CITY OF PORTLAND

August 7, 2001

RE: 167 Harris Avenue – 335-G-001 - R-3 Zone

MORTGAGE INSPECTION OF: DEED BOOK _____ PAGE _____ COUNTY Cumberland
PLAN BOOK _____ PAGE _____ LOT _____

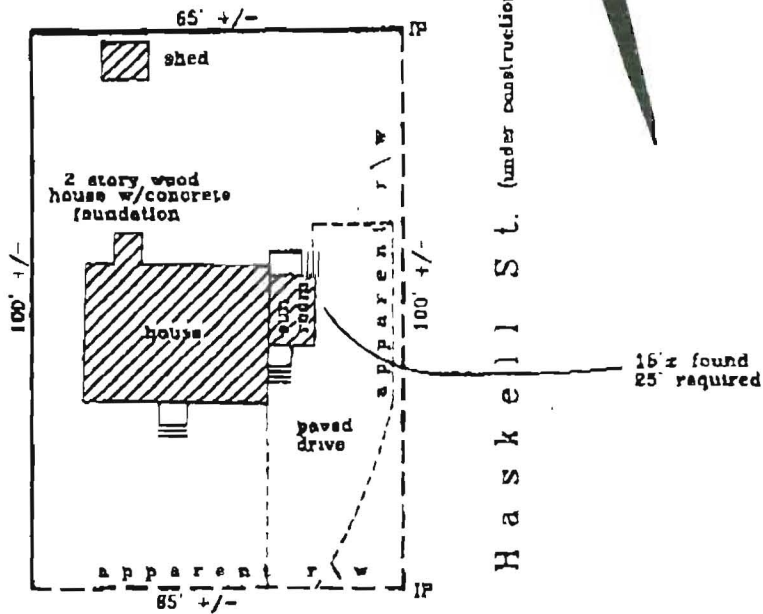
Recently it has been brought to my attention that the 8' x 12' deck and sunroom addition that was permitted and issued on April 11, 2000, was not constructed in the location noted on the submitted plans. Instead of a 30 foot setback on the left side of the principal structure, the deck and sunroom were constructed on the right side of the principal structure with a 16 foot setback, which abuts a paper street (Haskell St.).

Section 14-90 of the Zoning Ordinance requires a 20 foot side setback on a side street. 16 feet is being shown on a plan drawn by Livingston-Hughes Surveyors. Section 14-433 allows a reduction of side yards in the R-3 zone if the principal structure existed as of July 19, 1988. My research shows that the original house permit was issued in April, 1988 and that the principal structure existed as of July, 1988, so that this section of the ordinance may be applied.

I am allowing a reduction of the side yard from 20 feet to 16 feet using Section 14-433. This property is therefore not in violation of the zoning ordinance at this time. There is no appeal necessary.
